Application no: H11/1028/94

Description: Erection of bungalow and
garage

Location: 47 Little London
Long Sutton
Spalding
Lincs

Amendment: Amendment to windows/doors and chimneys, plus verge
detailing in lieu of fascia/argeboard (LS 94012/1/2)

drawing no
94012:2 A
date
11/10/95
scale
1:100
drawn
JAN '95

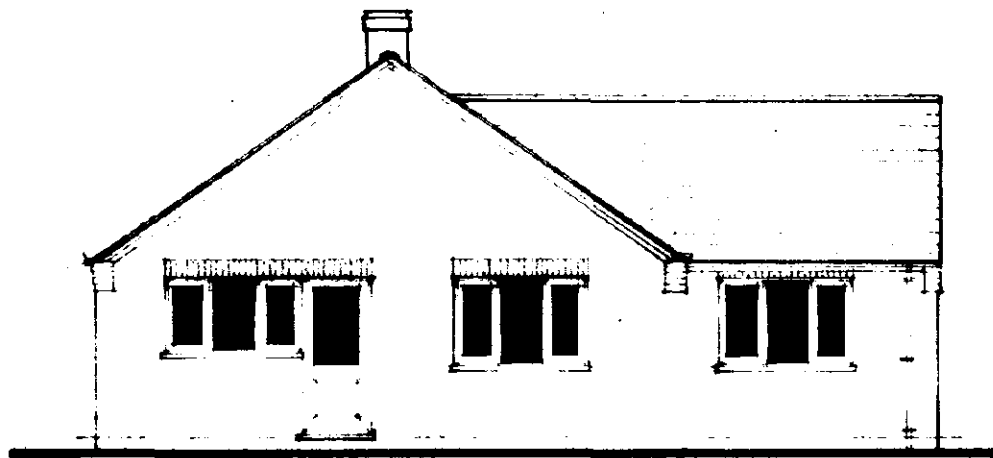
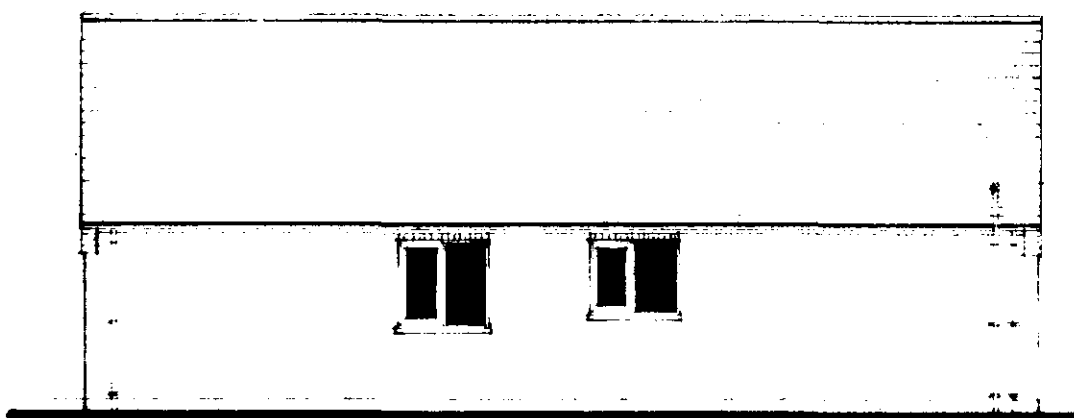
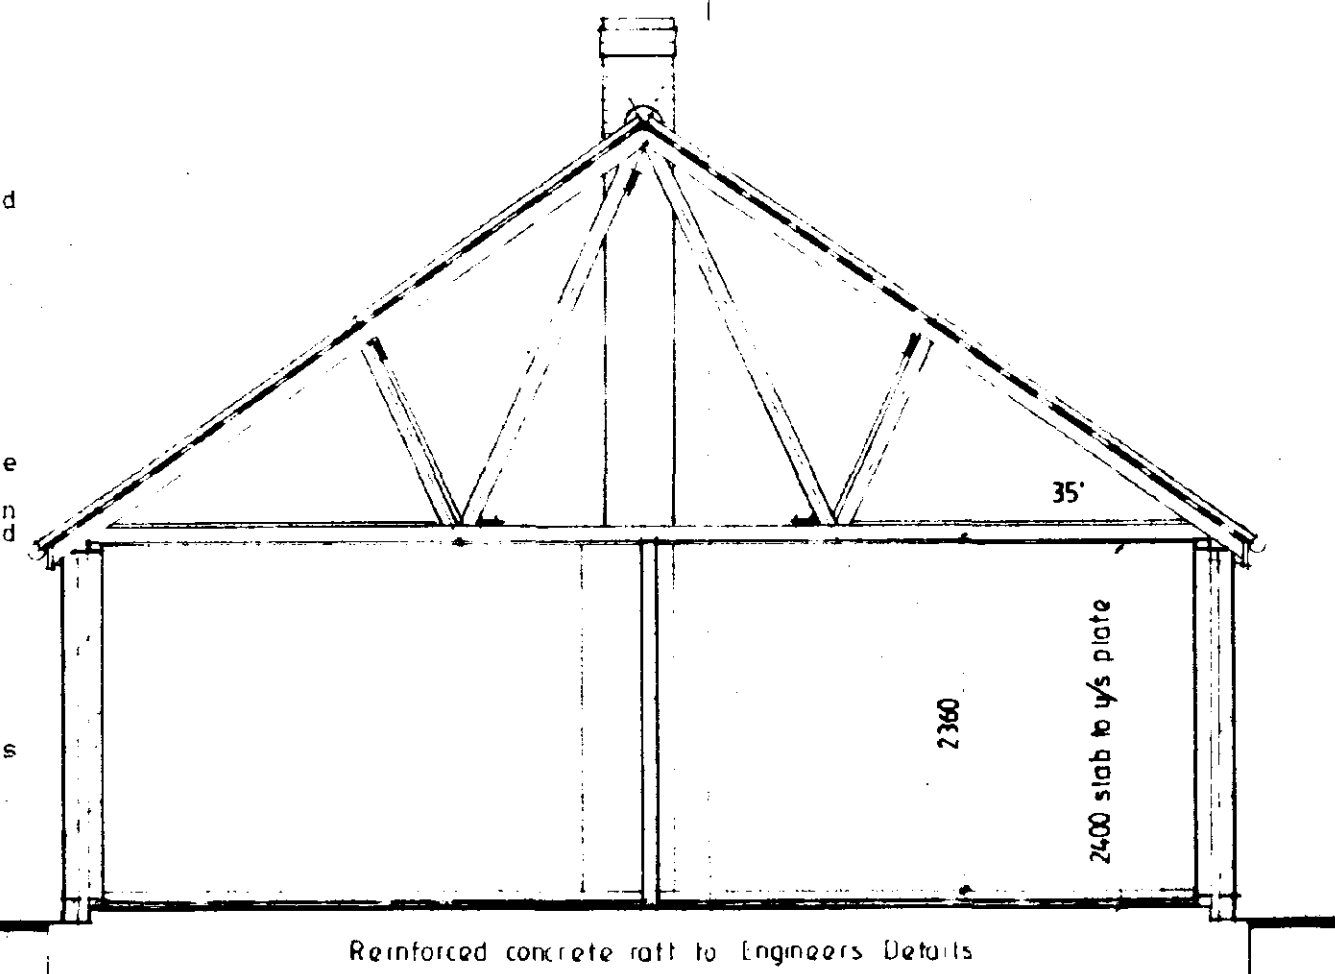
Dismissed with NDA.
New application required due to
significant reduction in height of
bragelows.

Amendment to windows/doors and chimneys, plus verge detailing in lieu of fascia/bargeboard.

Roof height now as per original.
